A303 Sparkford to Ilchester Dualling Scheme TR010036

8.18 Statement of Common Ground with Mr and Mrs A Walton, Long Hazel Park

STATEMENT OF COMMON GROUND

This Statement of Common Ground has been prepared and agreed by (1) Highways England Company Limited and (2) Mr and Mrs A Walton, Long Hazel Park

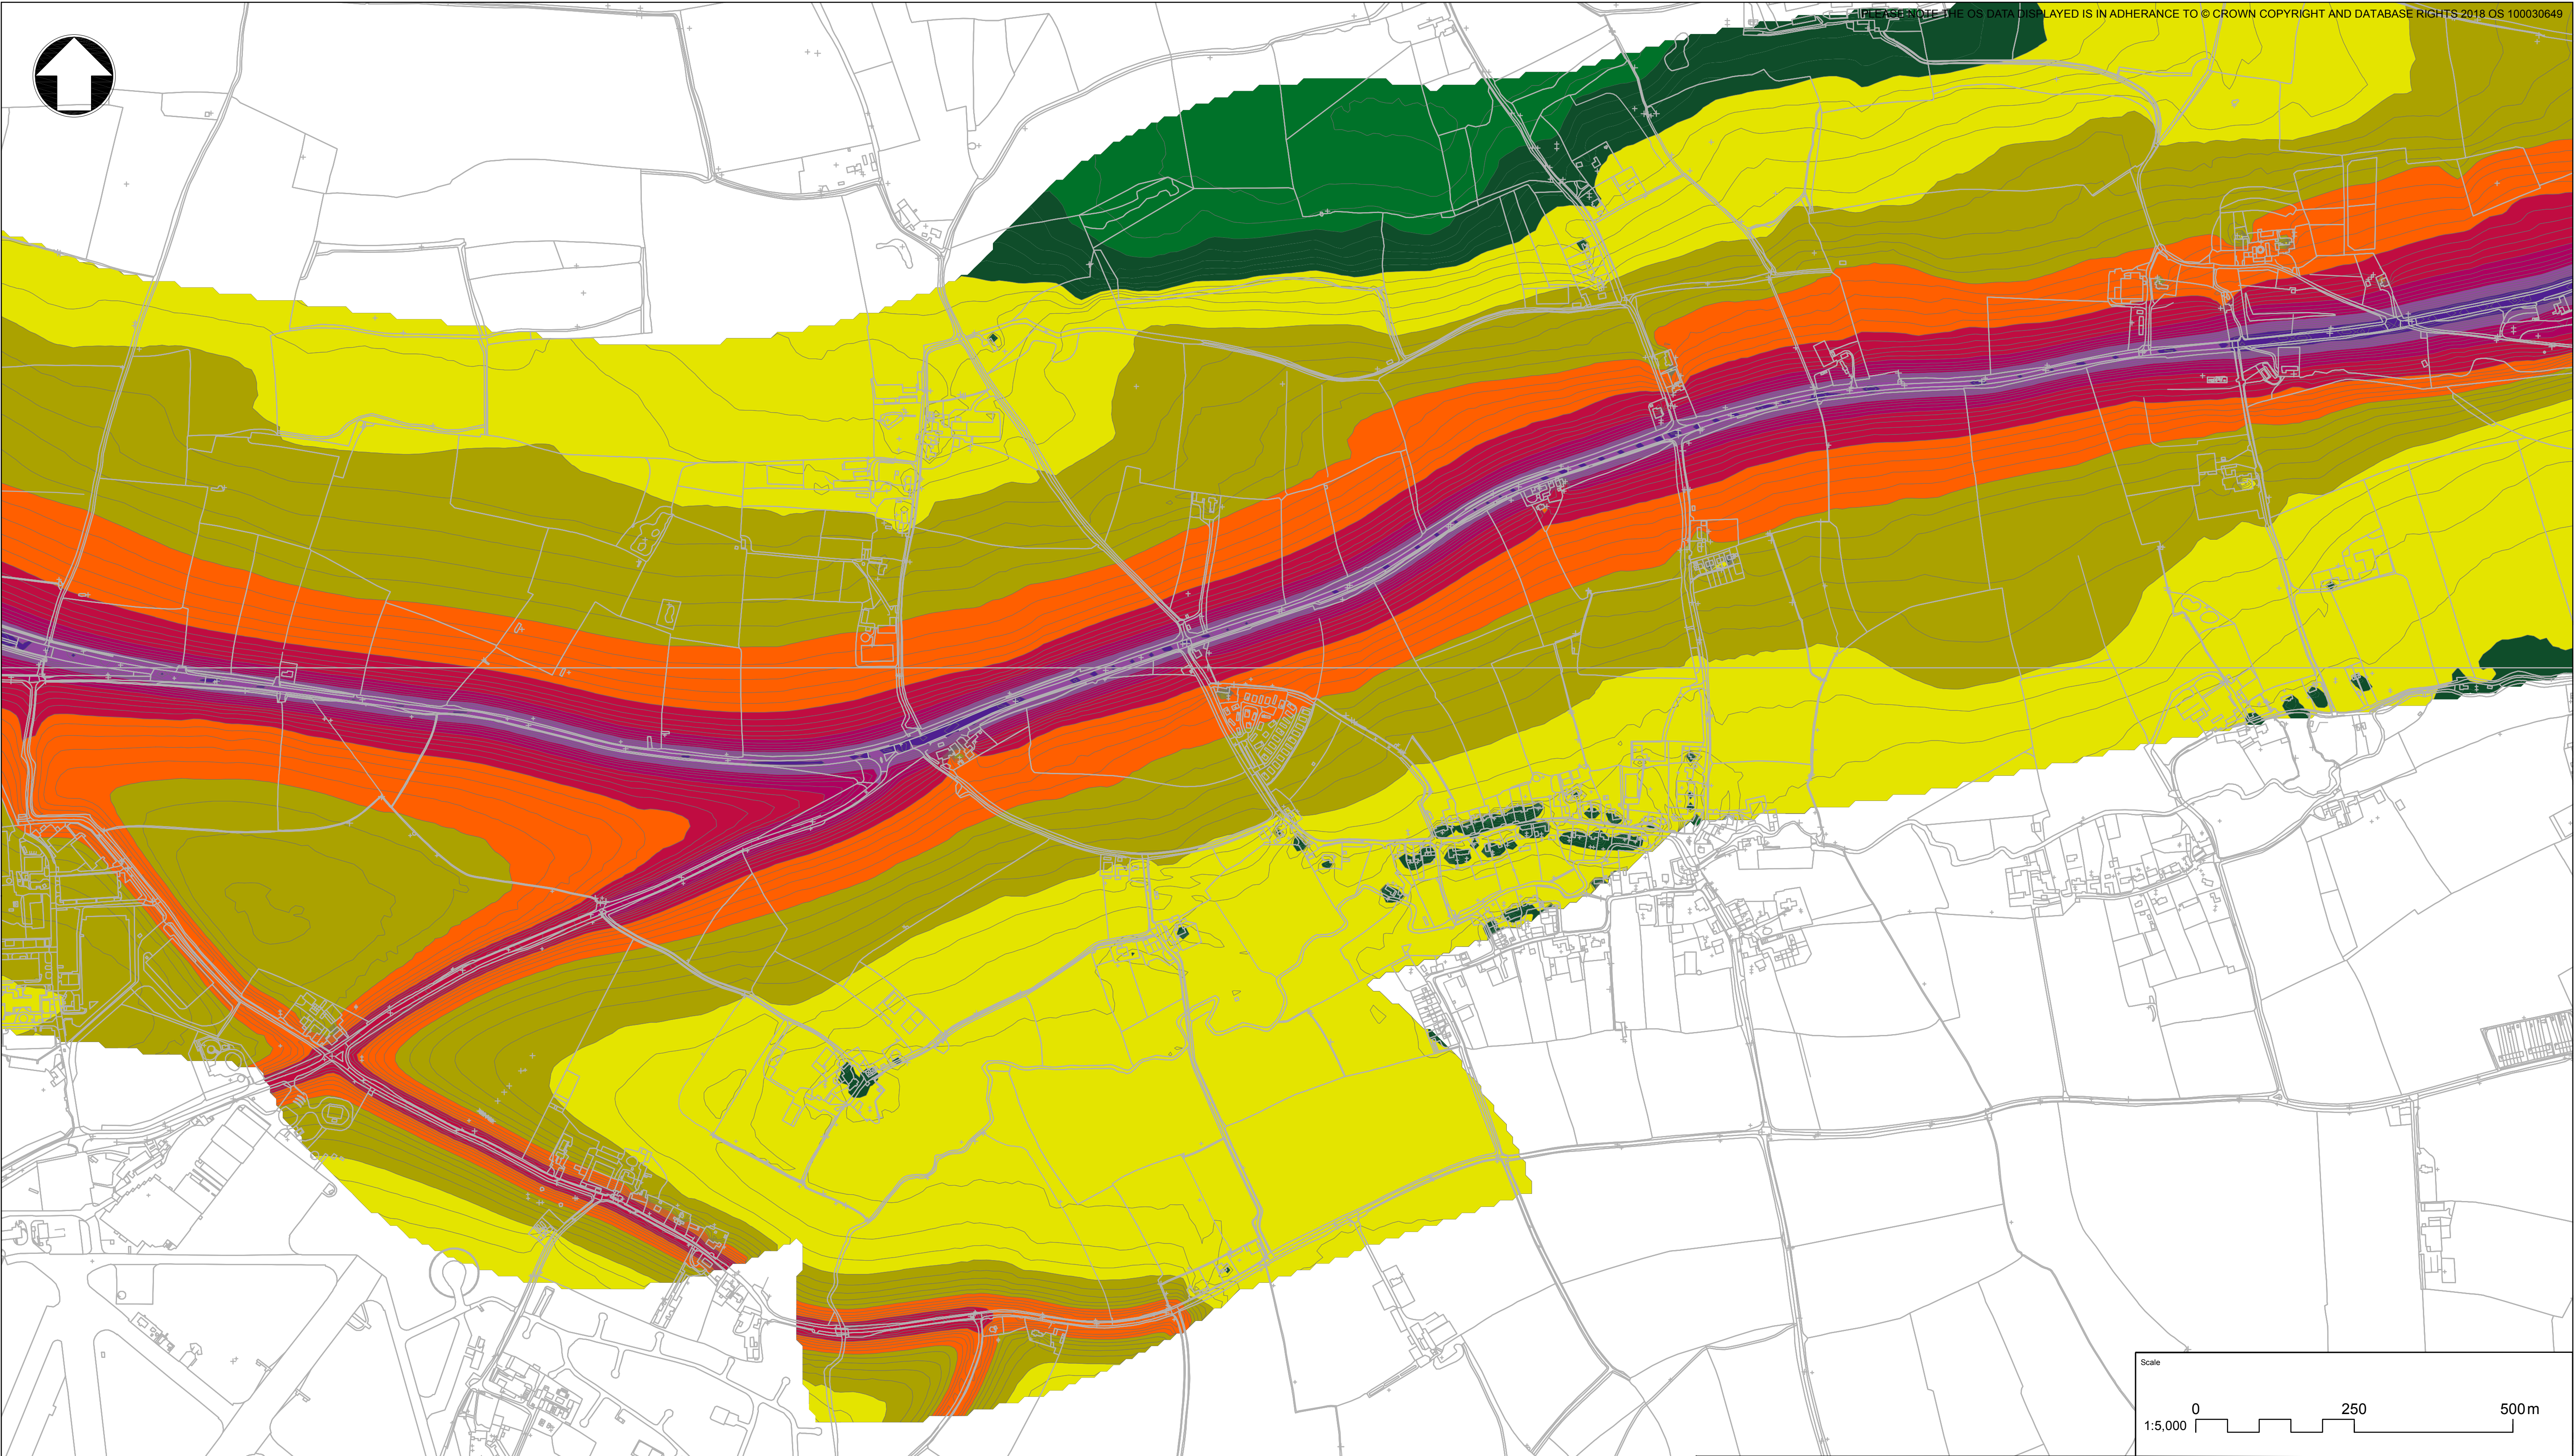
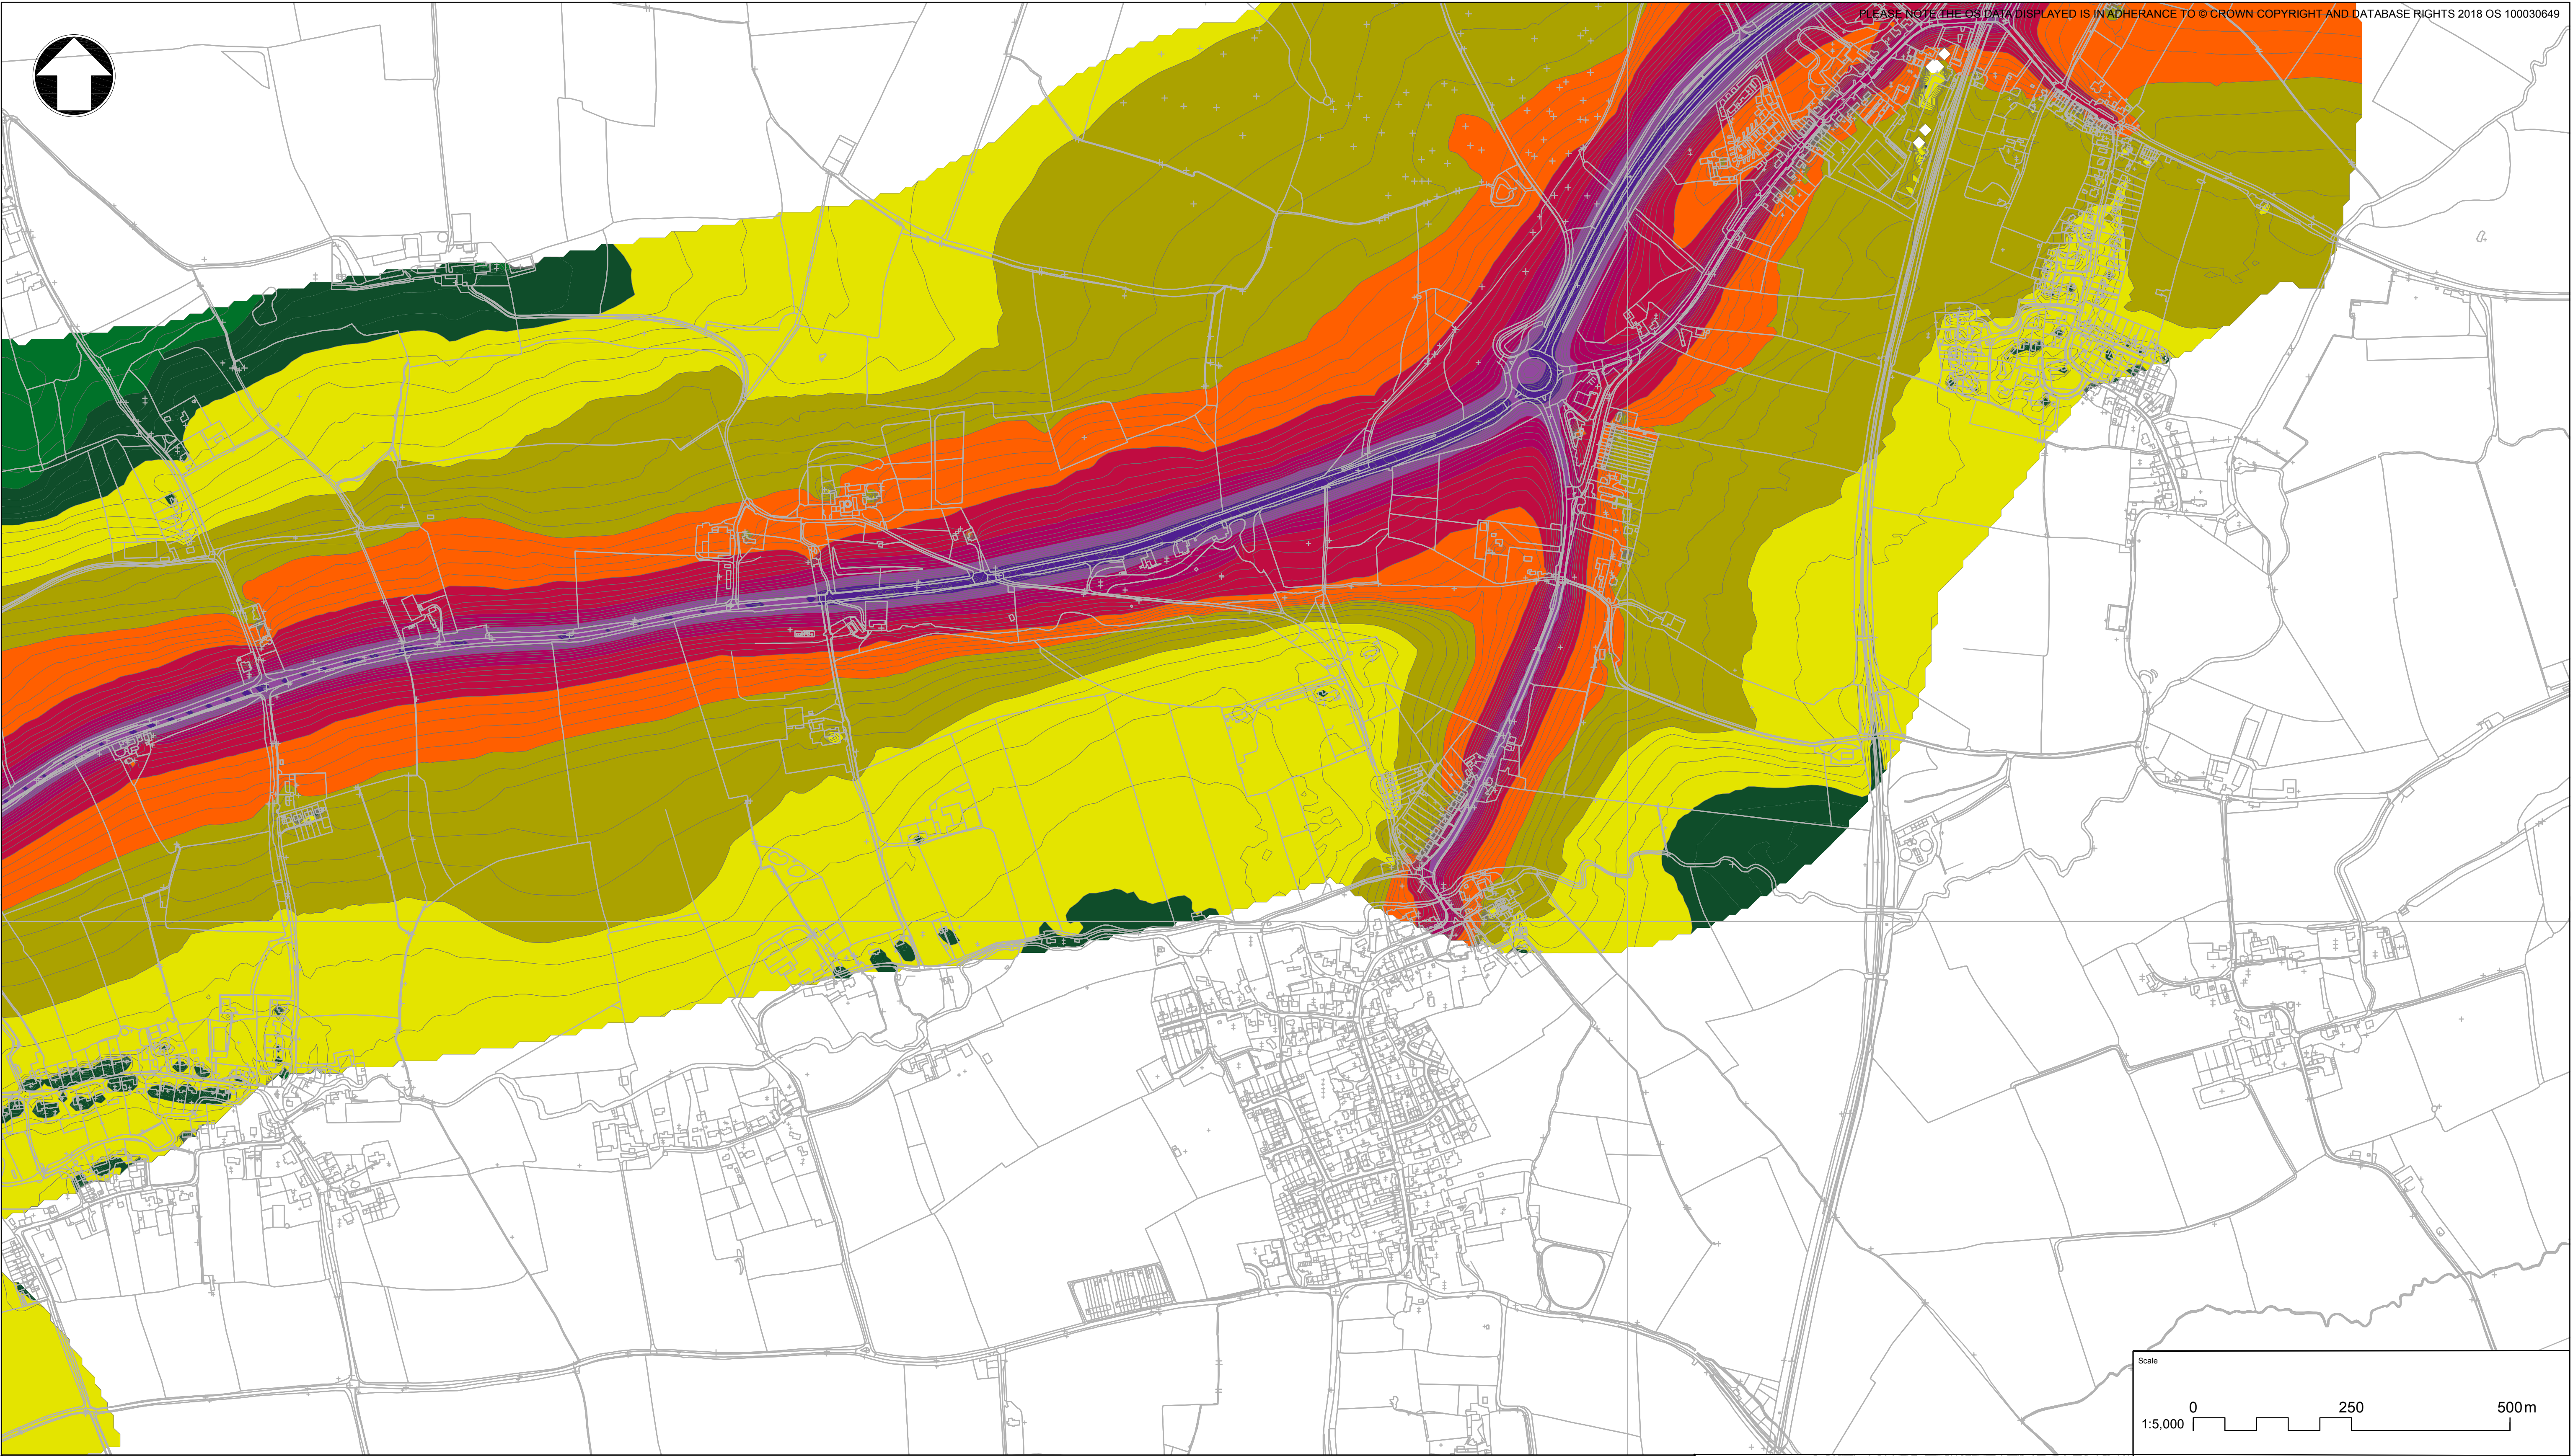
Noise predictions	In email correspondence, Highways England indicate that they estimate current traffic noise levels at	The predictions are based on a CadnaA noise model that implements details of the				AGREED

Topic	Mr and Mrs Walton's comment	Highways England response	Status
	<p>'Longhazel Caravan Park' to be 59.3 dB LA10 (18hr). They predict an increase of 2.2 dB in the short-term and 3.3dB in the long-term. This assessment is based on distances to AddressBase data points and not to property/land boundaries. So some lodges on the site might suffer greater exposure.</p> <p>Therefore, it would appear that by "Design Year", noise levels would have increased to around 62.6 dB LA10 (18hr).</p>	<p>topography, vertical and horizontal alignment, flows, road surfaces and many other factors and not just distances. The reported level was for the OS database receptor within the caravan park which is the home of Mr and Mrs Walton. It is correct that some lodges on the site are exposed to higher noise levels than Mr and Mrs Walton's home but none are exposed above the SOAEL in either the DM or DS cases in either the opening year or the design year (2038). The level of 62.6dB is the level at 4m (corresponding to first floor window) and for which a façade value correction of +2.5dB has been applied to account for sound reflection from the building. The level at the ground floor and without the façade correction would be lower.</p>
